Consultation response

AB/72/20/HH

Riversong 19C River Road Arundel BN18 9EY

Replace the existing balcony, rebuild boundary walls and other alterations

River Song - Arundel - Proposed Arrangement

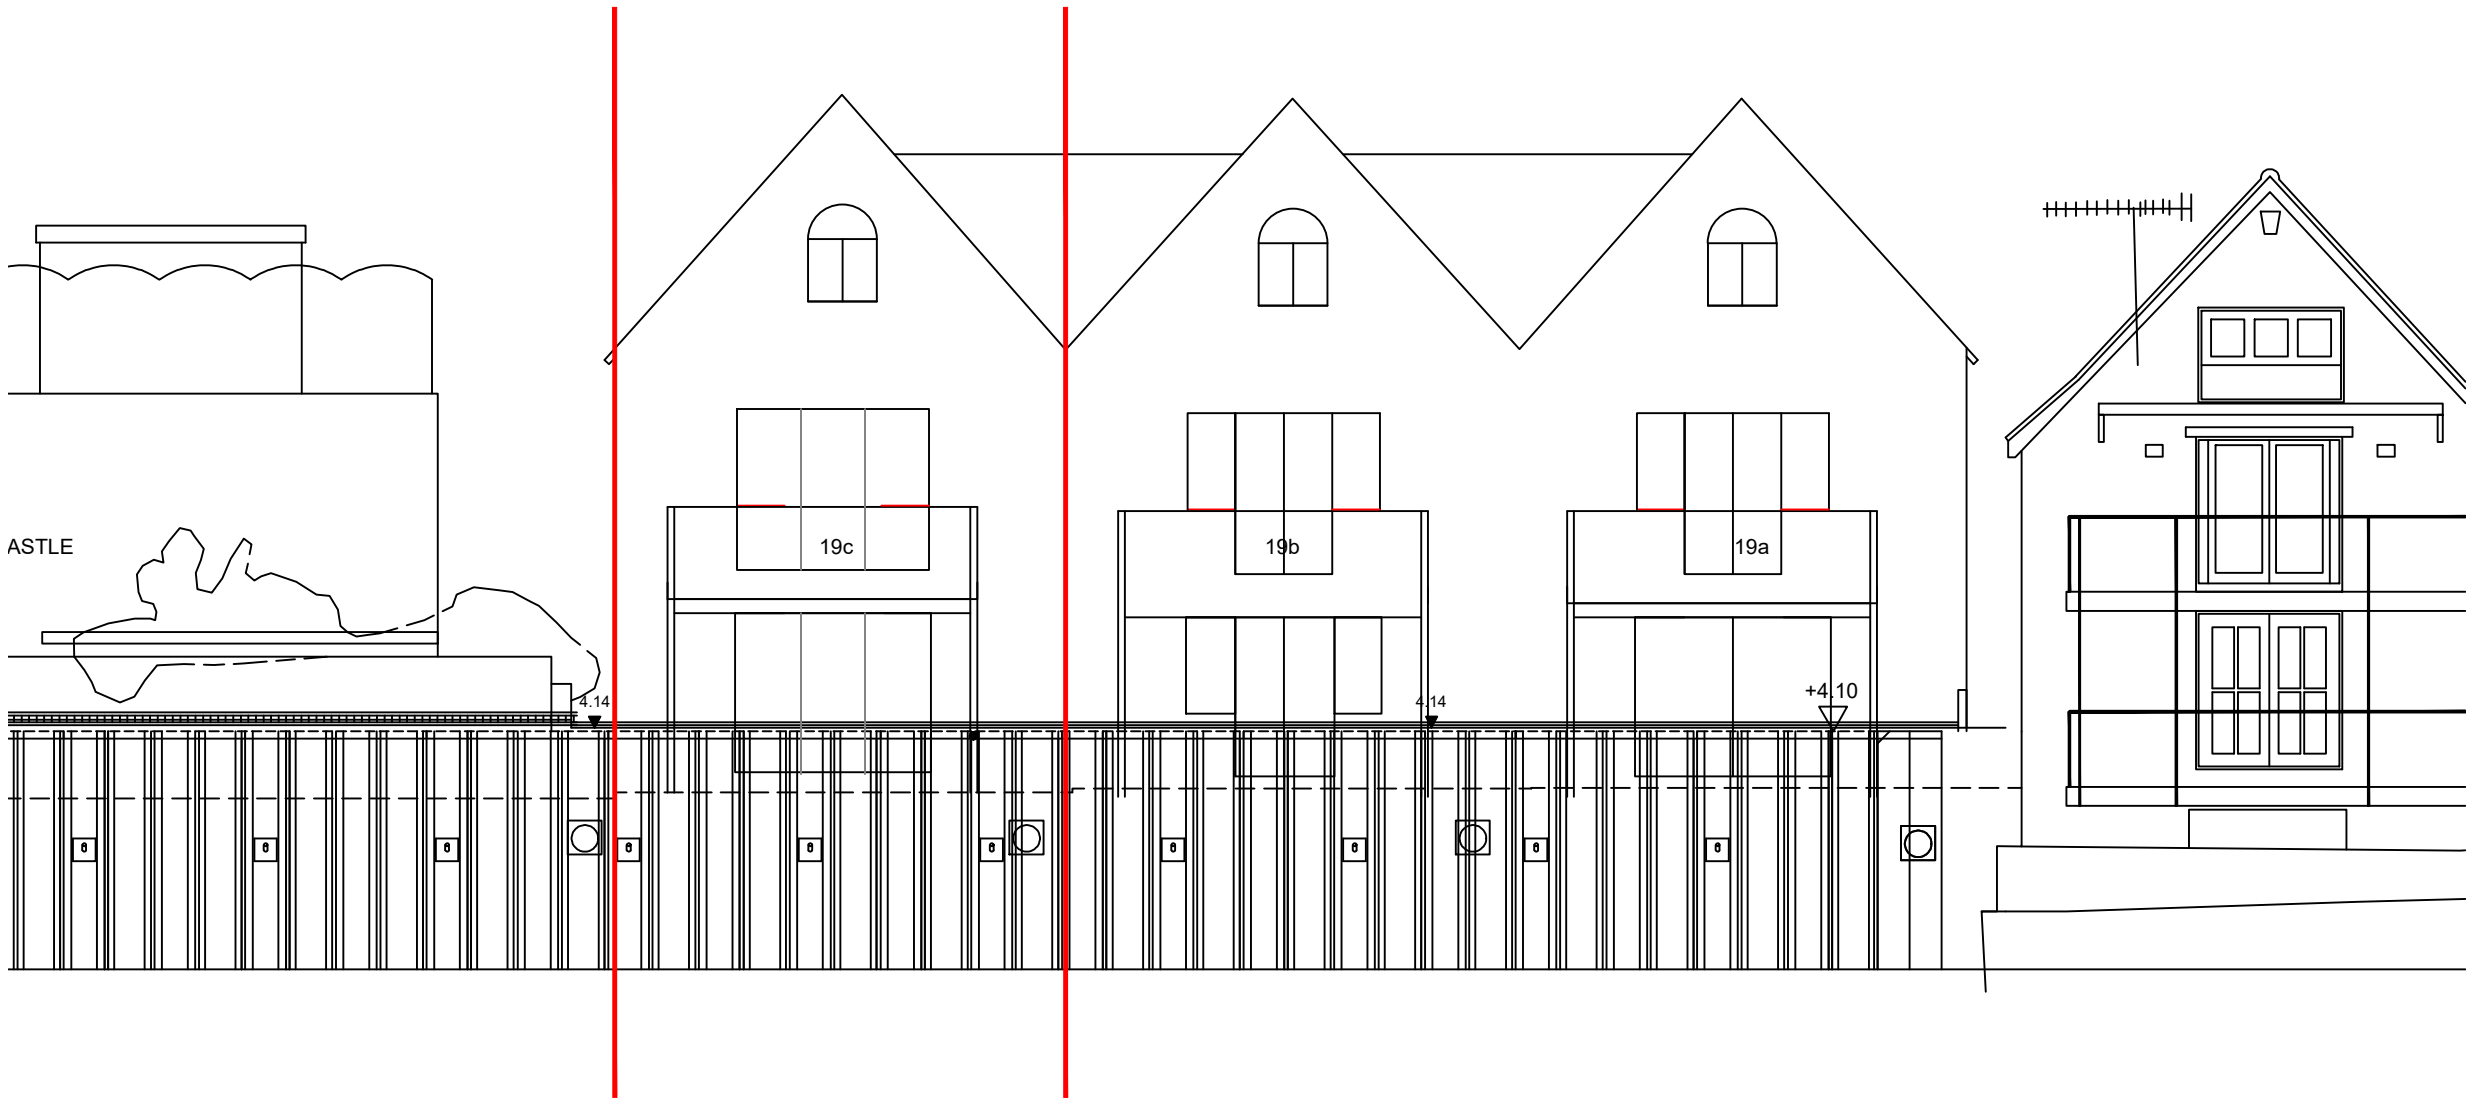
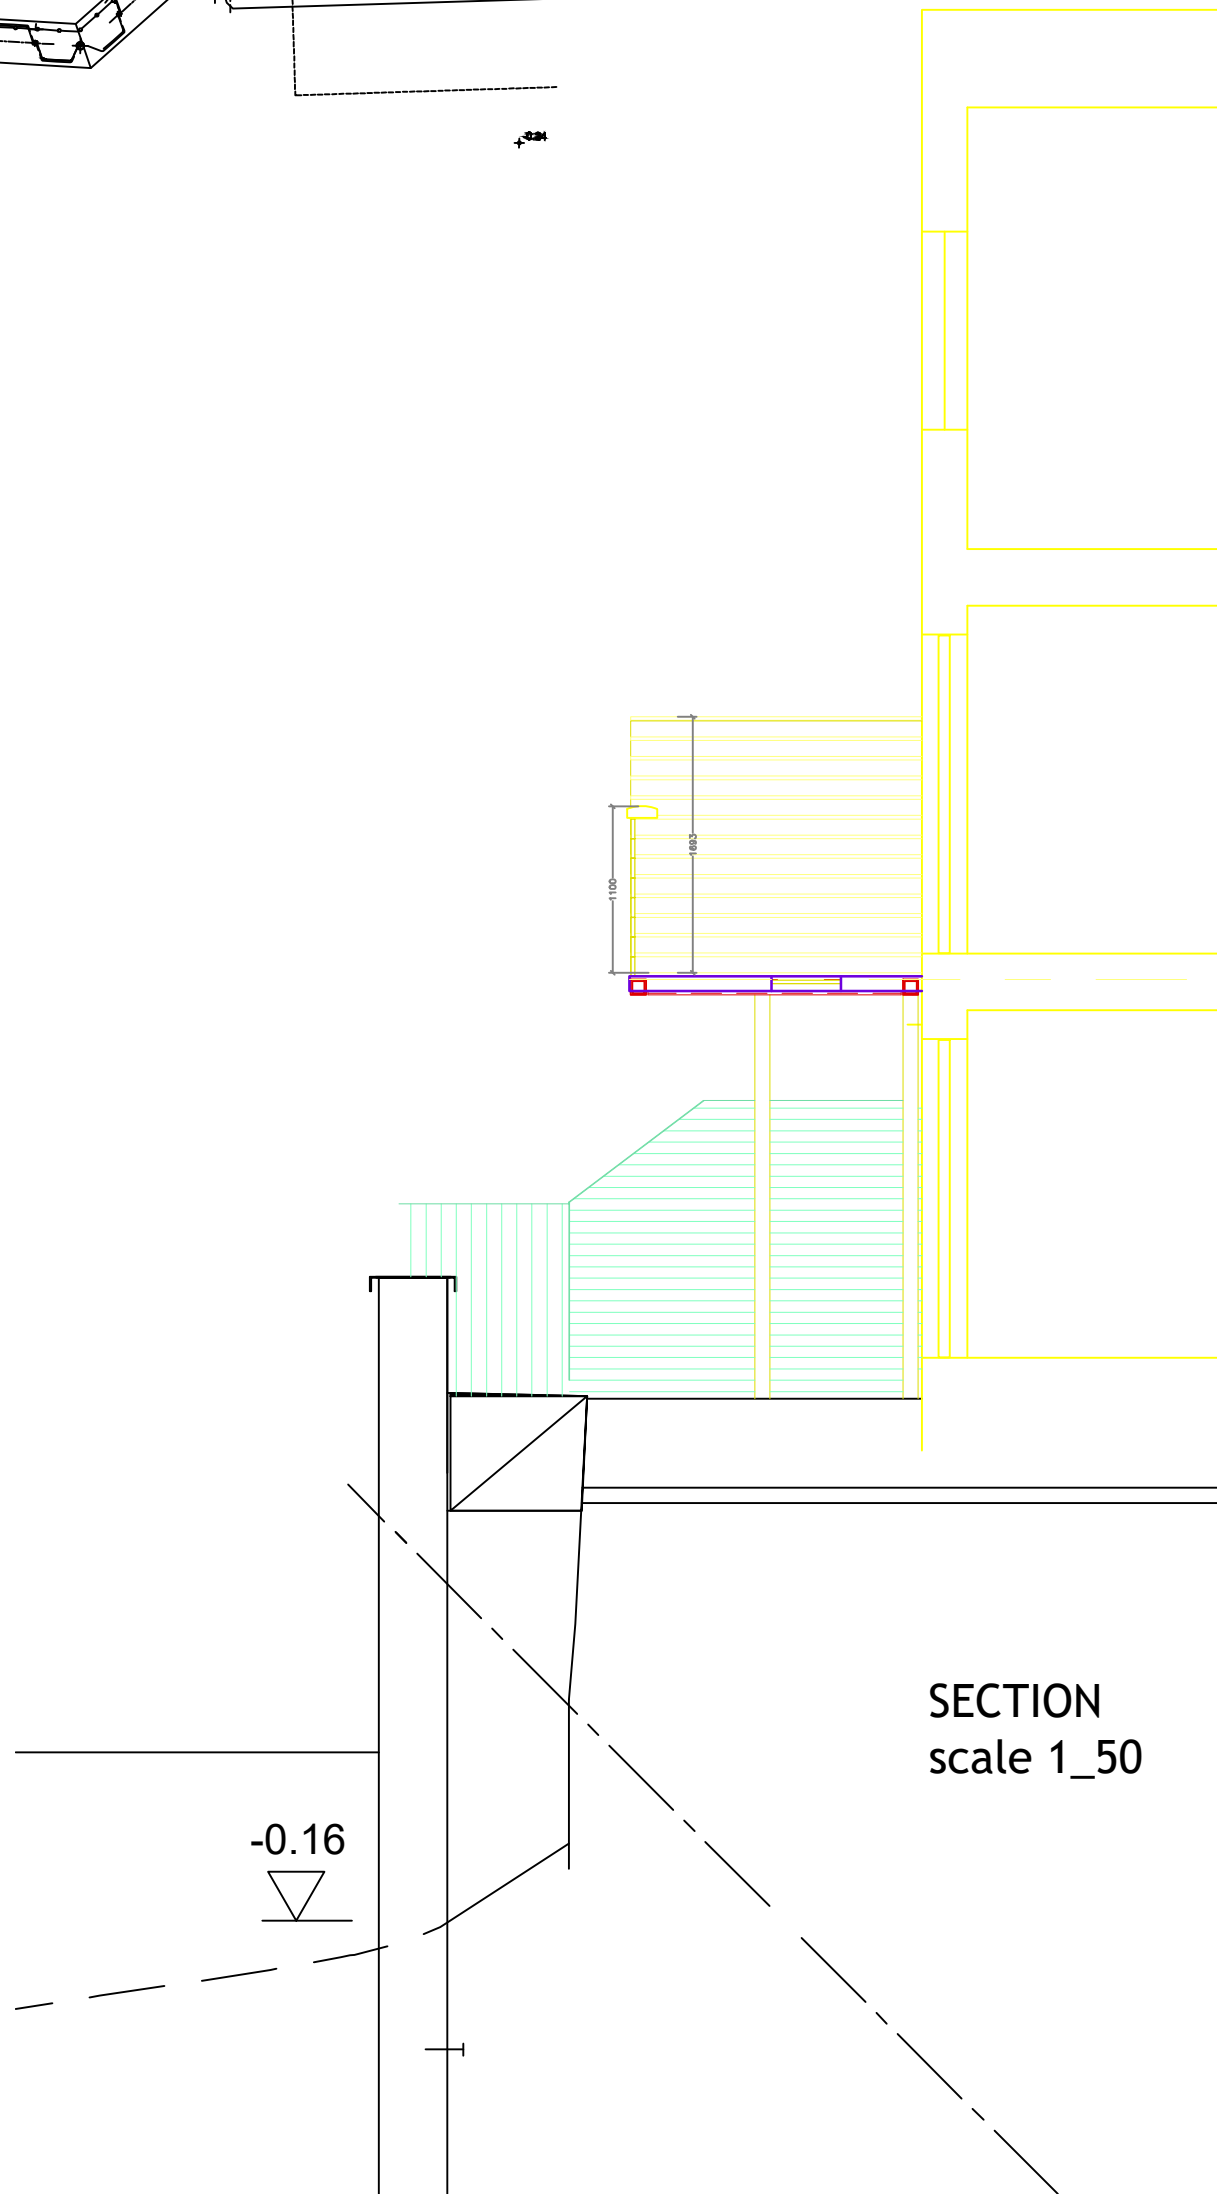
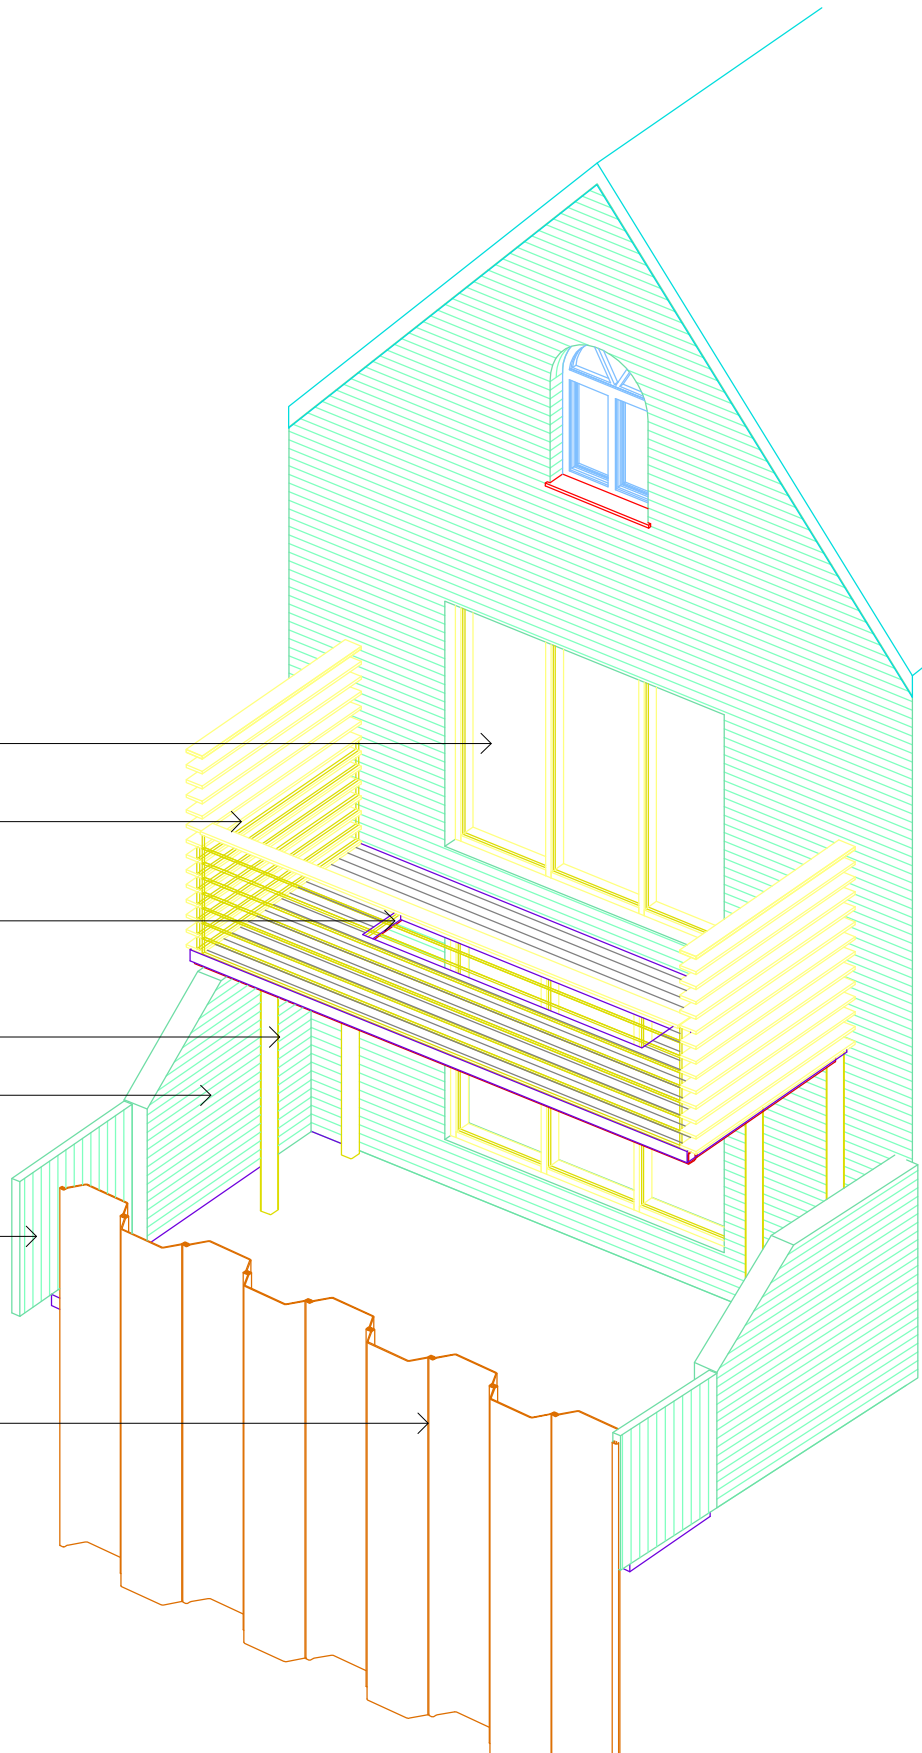
The proposal relates to a more recent building which consists of a terrace of three houses. The new balcony will replace an existing one which has apparently been damaged as a result of the neighbouring flood defence works. The proposed design is modern in appearance and, if carefully detailed could be acceptable. However, at present, there is the chance that it will be somewhat visible from the river and various vantage points. The impact of the scheme will be greatly reduced if the other two balconies on the same elevation were to be of the same design/appearance.

On balance, it is suggested that the balcony will have a neutral impact, subject to the careful use of materials and colours. The application is considered to not cause harm to the significance of the heritage assets. As a consequence, it should be determined in accordance with the relevant policies within the Development Plan, along with these comments. You will also need to take into account the contents of the Planning (Listed Buildings and Conservation Areas) Act 1990 (as amended).
